CAWSTON PARISH COUNCIL NORFOLK BOREAS OFFSHORE WINDFARM INQUIRY

DEADLINE 18 SUBMISSION

TITLE  
 CAWSTON HIGHWAY  
 INTERVENTION SCHEME  
 SWEEP PATH ANALYSIS  
 ARTICULATED AND LARGE TIPPER  
 VEHICLES - TWO WAY MOVEMENTS

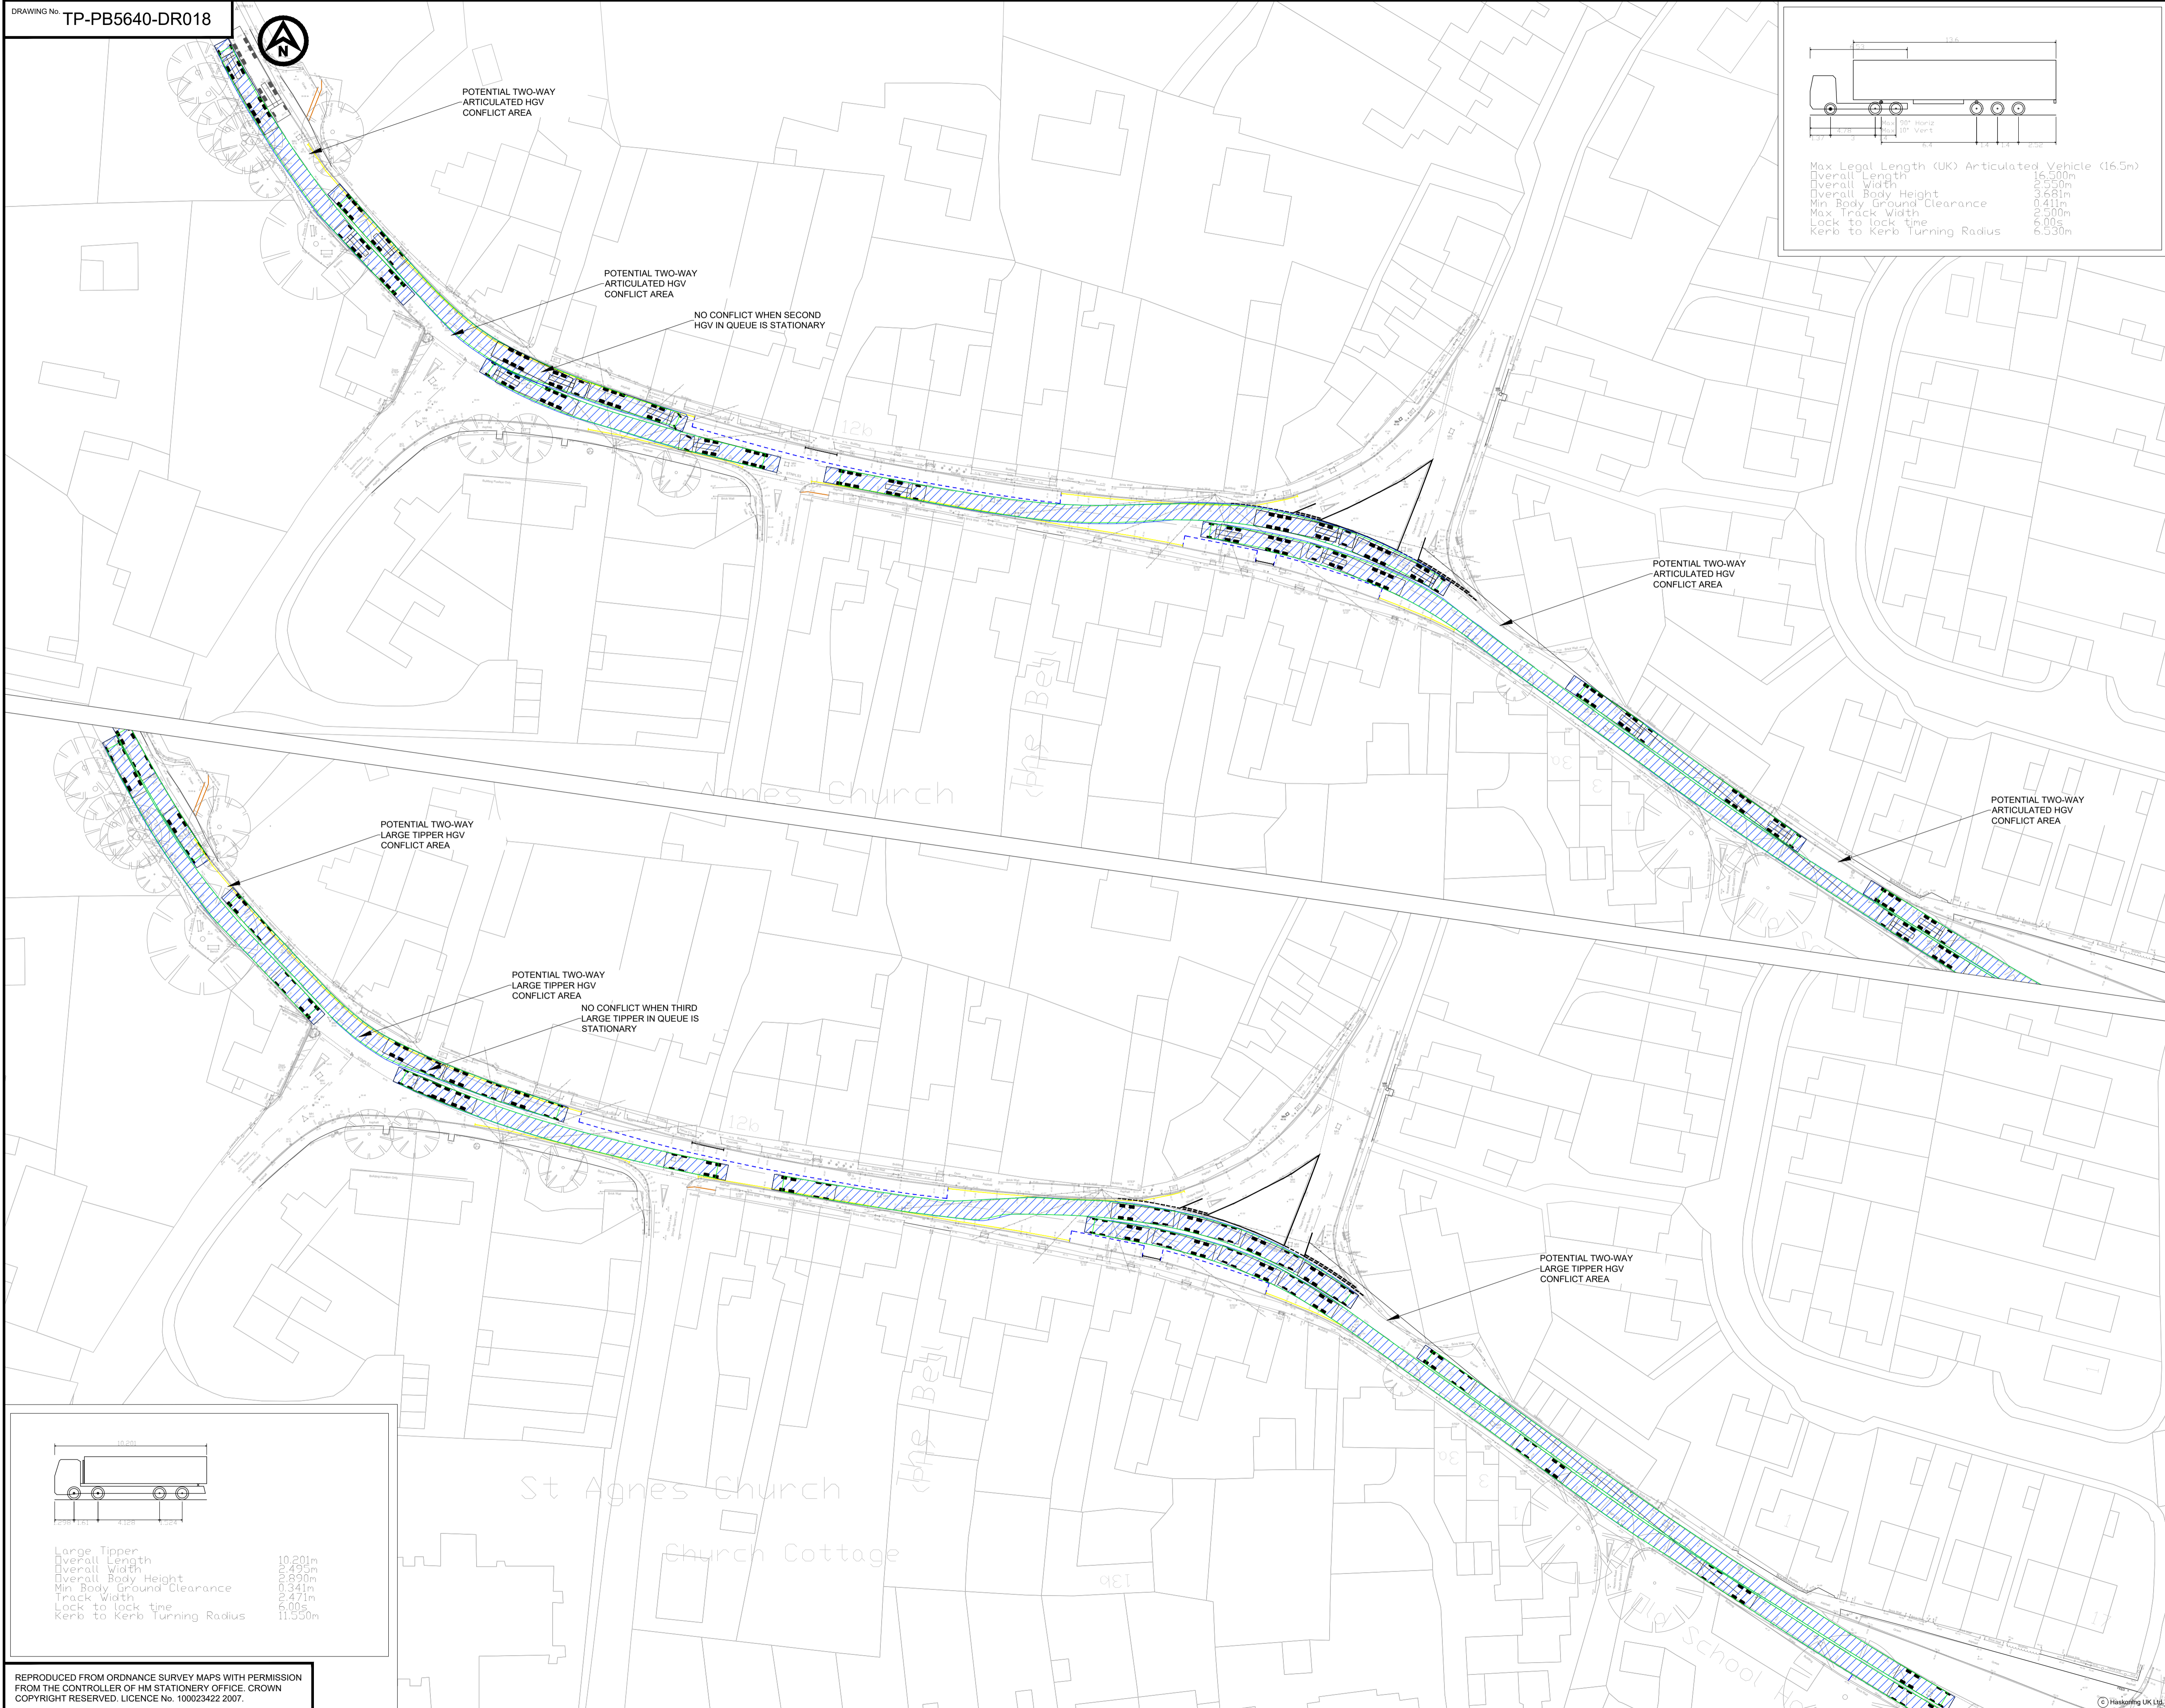
Despite the “unprecedented” scrutiny of the HIS the Applicant still fails to respond to our legitimate and well-founded concerns. Earlier in the inquiry the Applicant produced maps showing swept path diagrams to support their claims that, despite all the evidence, the B1145 in Cawston and their deluded plan for passing spaces would be safe and effective. Now, as it becomes clear that the passage of more than a hundred vehicles with loads 3.3 metres wide through the village is proposed, the Applicant does not see the need to produce revised swept paths.
